CITY OF ALBUQUERQUE

**RE: Alameda Development
6100 Alameda NE
Conceptual Grading and Drainage Plan
Engineer's Stamp Date: 12/06/18
Hydrology File: C18D086**

Based upon the information provided in your resubmittal received 12/06/2018, the Conceptual Grading and Drainage Plan is approved for action by the DRB on the Site Plan for Building Permit.

Conceptual
Grading Plan
date:
8-17-18
sheet:
3

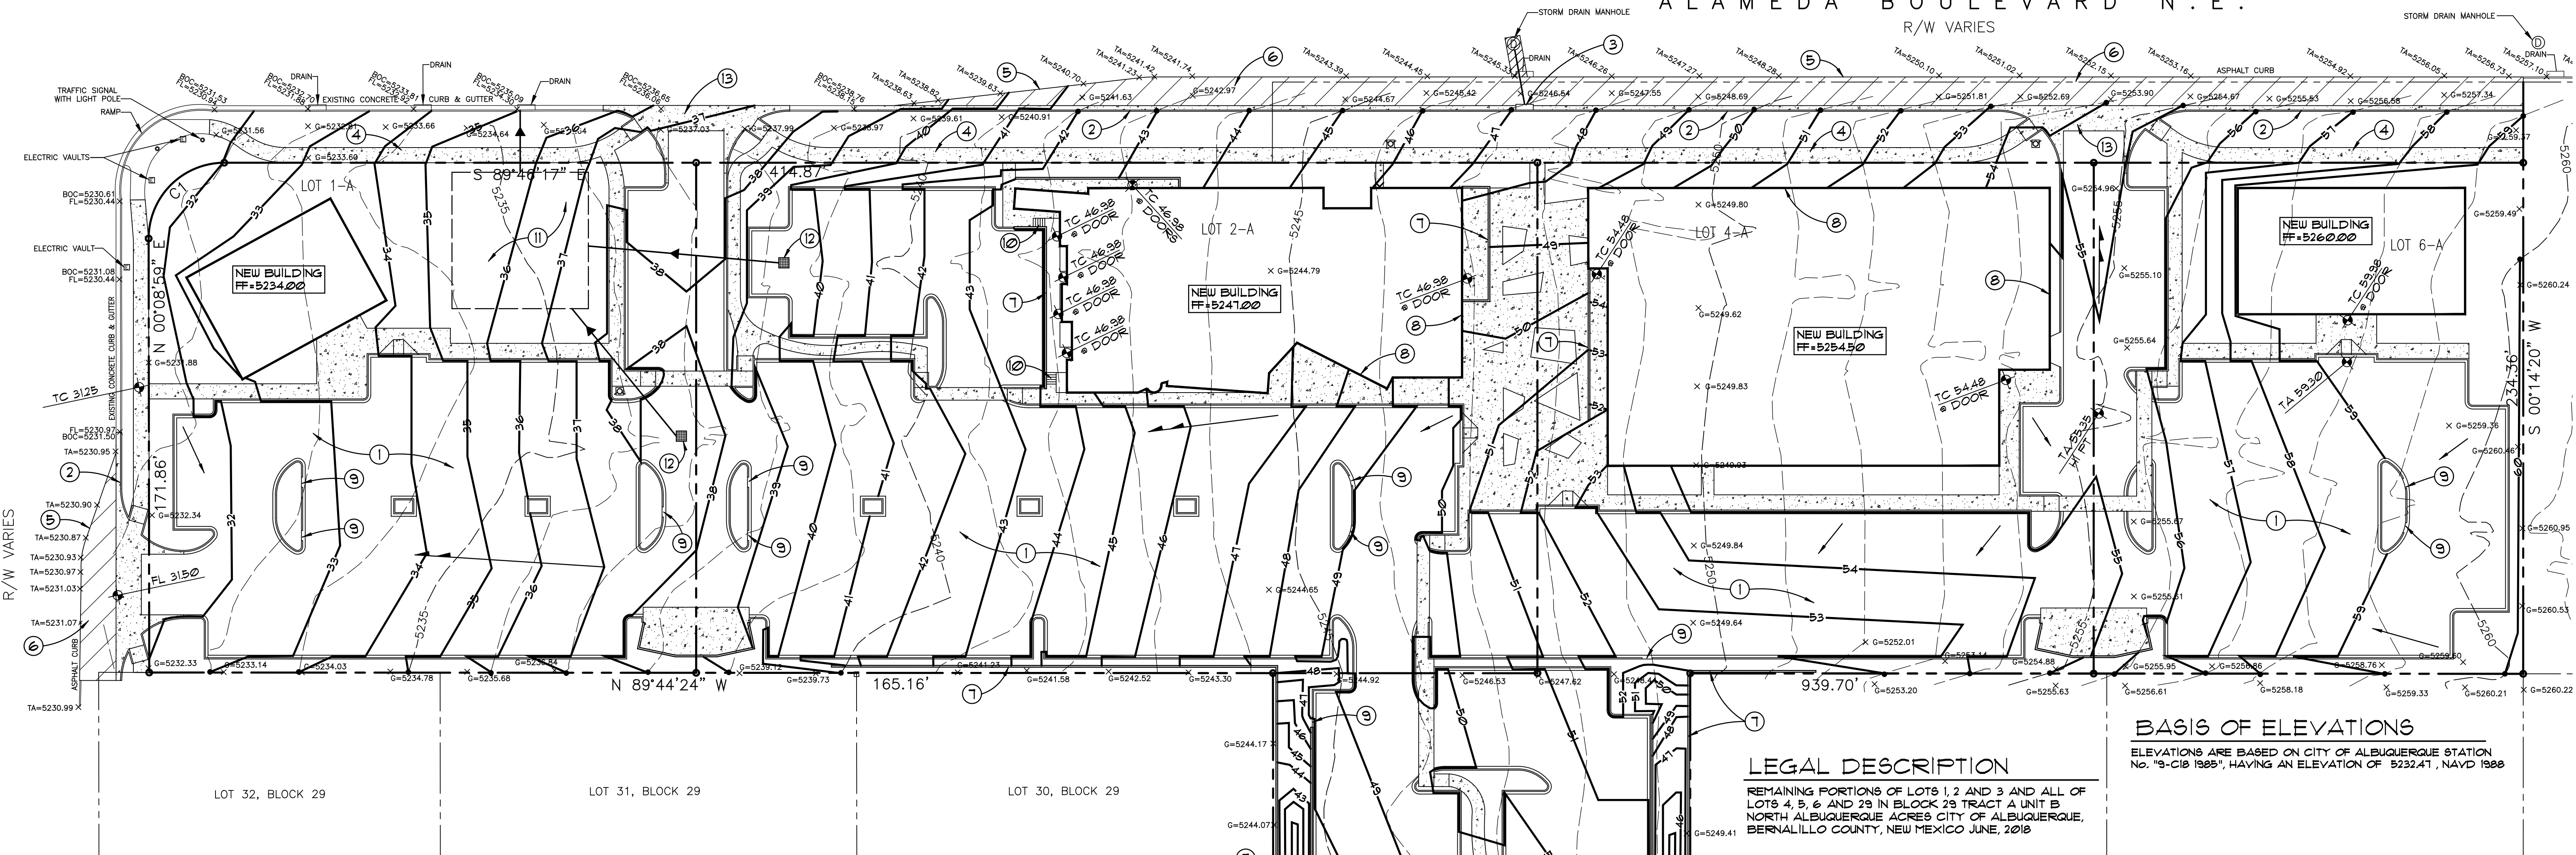
1. Sheet 3. Basin II is missing the northern boundary line along, please add this.
2. Sheet 3. Please reevaluate Basin II's area. It appears that a portion of the building on Lot 2-A and drive entrance should be included in Basin III which discharges into the underground system.
3. Sheet 3. Please add a water block at the entrances to Alameda Blvd and Signal to ensure that drainage does not leave the site.
4. Sheet 3. Please add an inlet within the drive entrances along Alameda to capture the runoff and direct it to Drainage Point "A".
5. Sheet 3. Please add a berm or add a grade line to redirect the runoff to the proposed inlet in Basin IV. The grading as is appears to allow runoff into San Pedro.
6. Sheet 3. Please call out the storm pipe size.
7. Sheet 3. Please show and label the volume provided for the

1. The north boundary line for Basin II has been added to the plan.
2. The area for Basin II has been revised and the change is reflected in the runoff calculations submitted in our Drainage Report.

3. Water block changes have been made at the San Pedro, Signal and Alameda drive entrances to the site.
4. This comment was eliminated per our email/telephone conversation.

5. A landscape berm has been added to prevent runoff from exiting the site into San Pedro Blvd.
6. Storm drain line sizes have been added to the plan.
7. The storm water quality volumes and BMP facilities have been identified in the calculations and on the plan.
